App No: AL/57/18/OUT

Address: Land East of Lidsey Road Lidsey Road Woodgate PO20 3SU

Proposal: Outline application with some matters reserved for the erection of 30 No. dwellings consisting of 4 No. 4-bed houses, 10 No. 3-bed houses, 4 No. 3- bed apartments, 8 No. 2-bed apartments & 4 No. 1-bed apartments, communal work hub with associated car parking & landscaping. This application is a Departure from the Development Plan.

Tree Constraints Plan

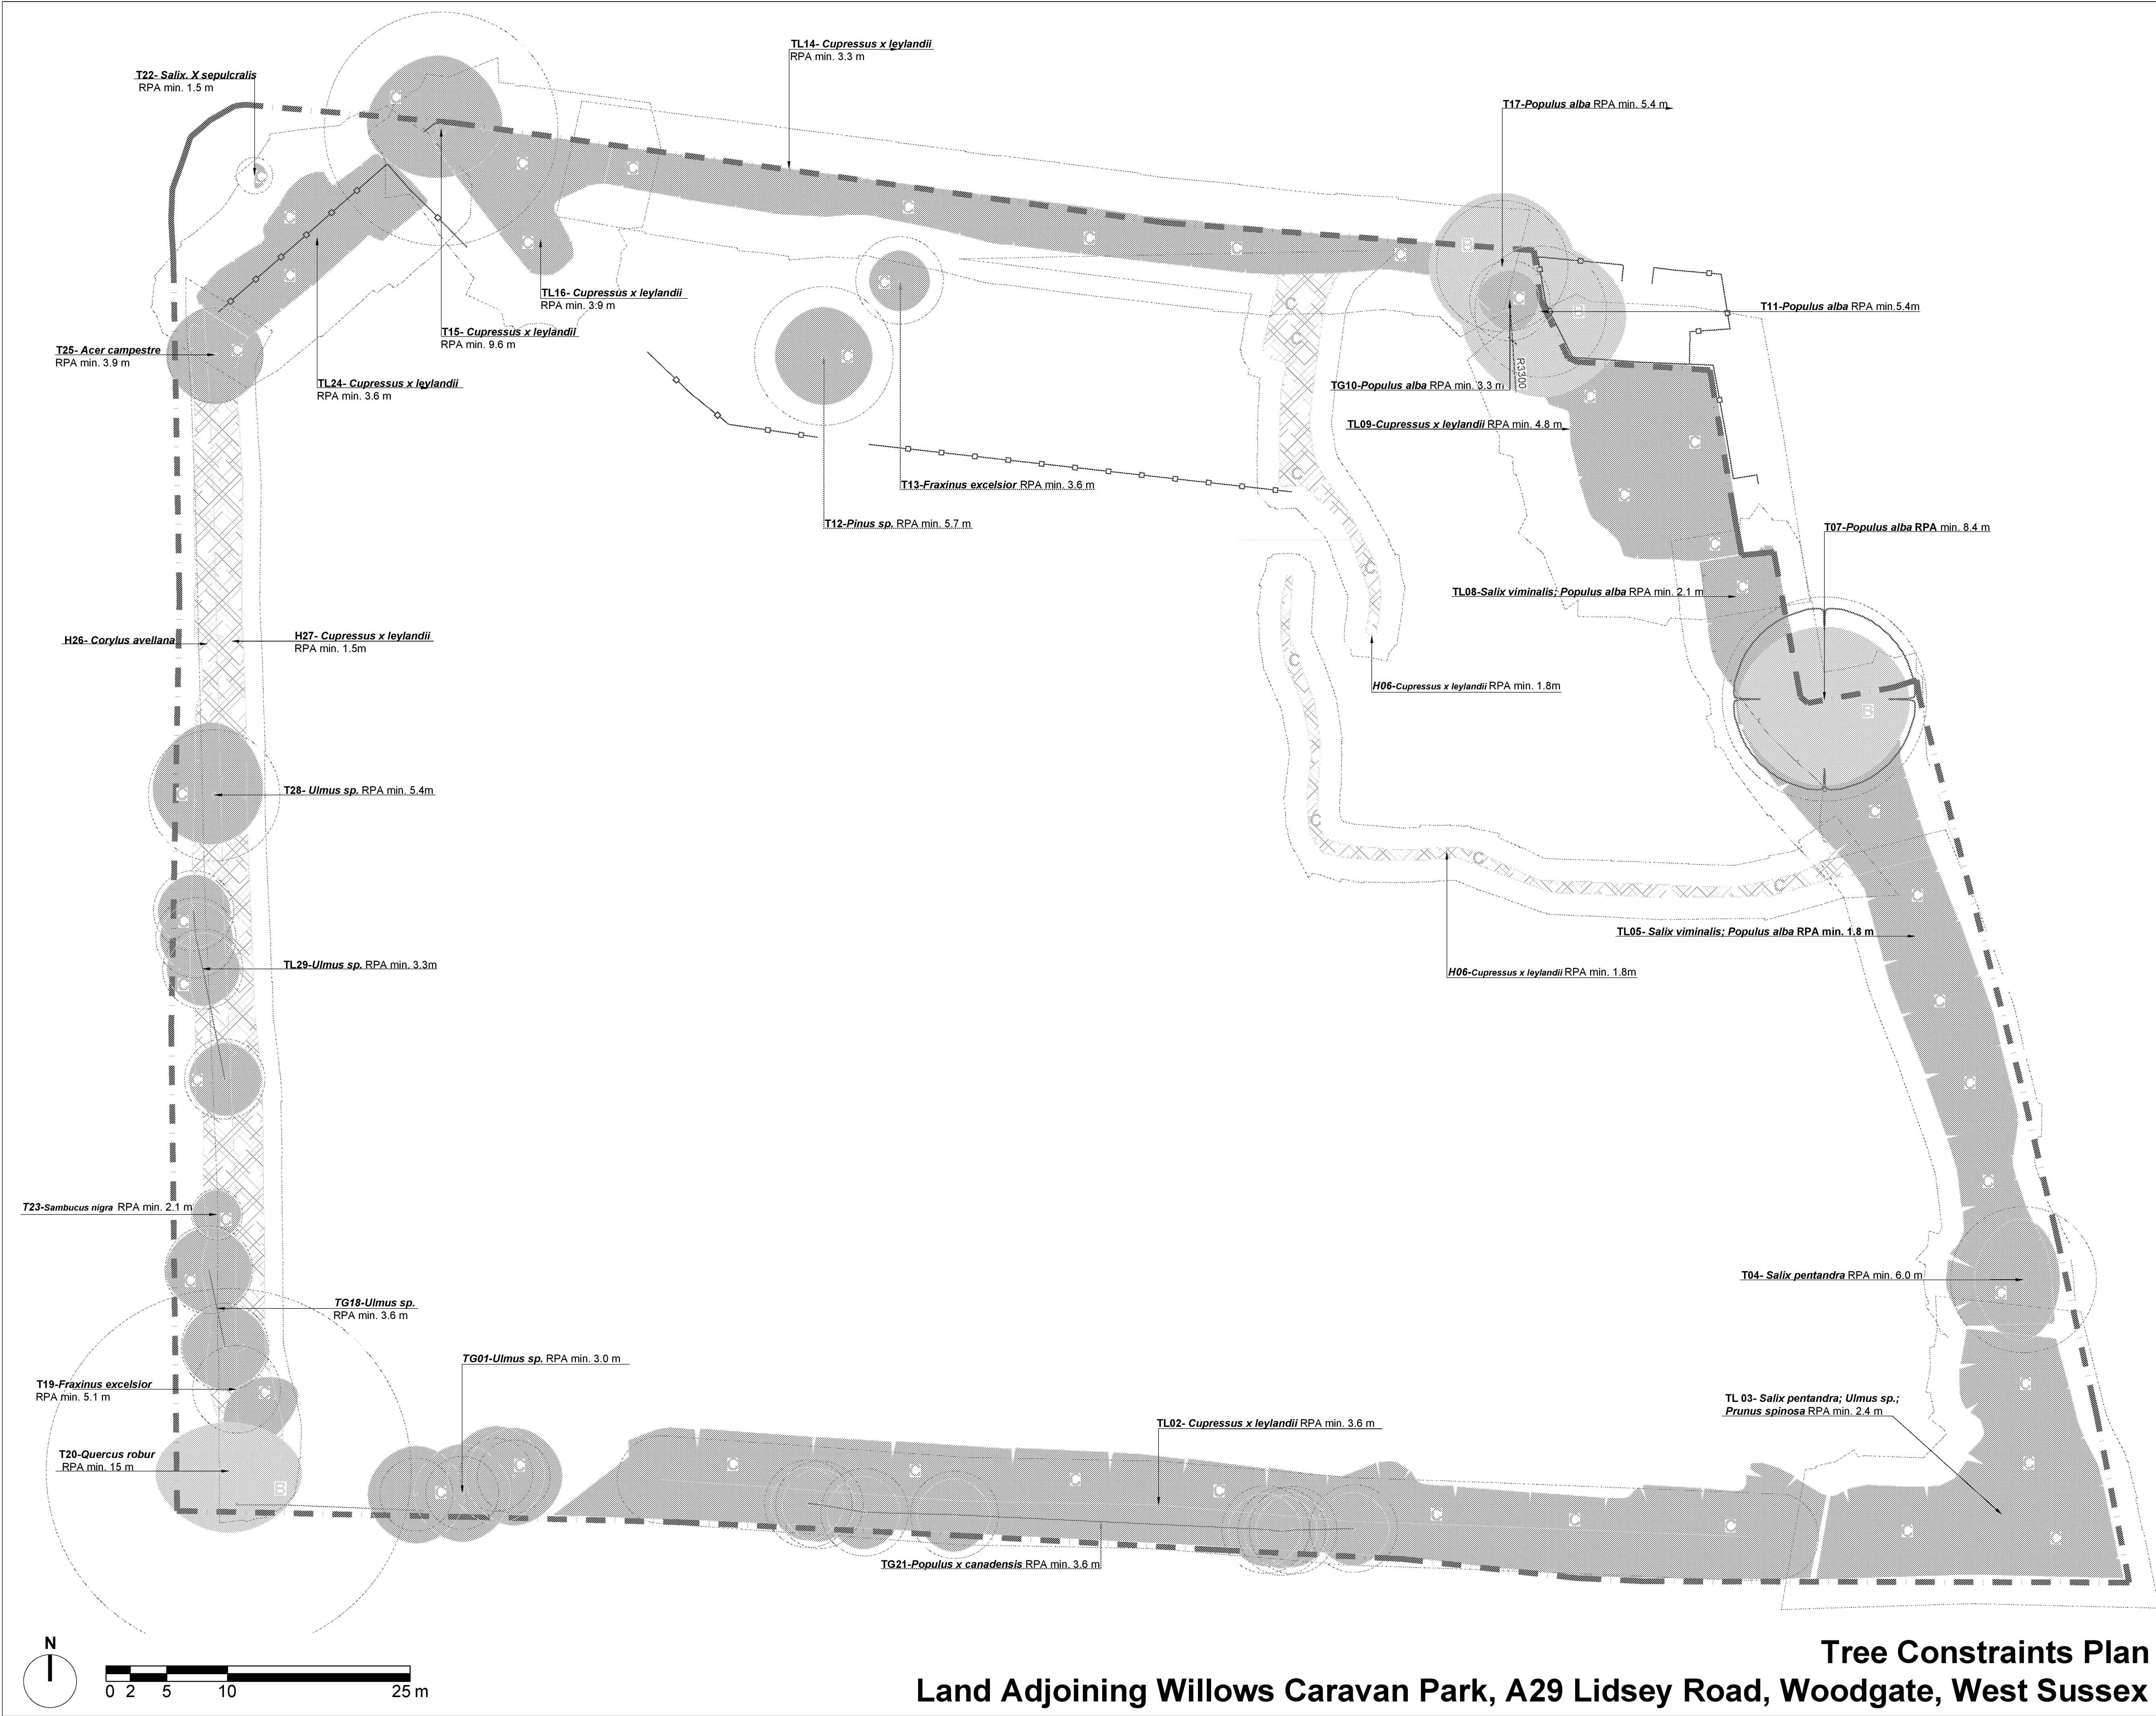
One tree (T01) has been identified as being suitable for bats, currently this tree is being retained however if it needs to be removed further survey work for bats would be required.
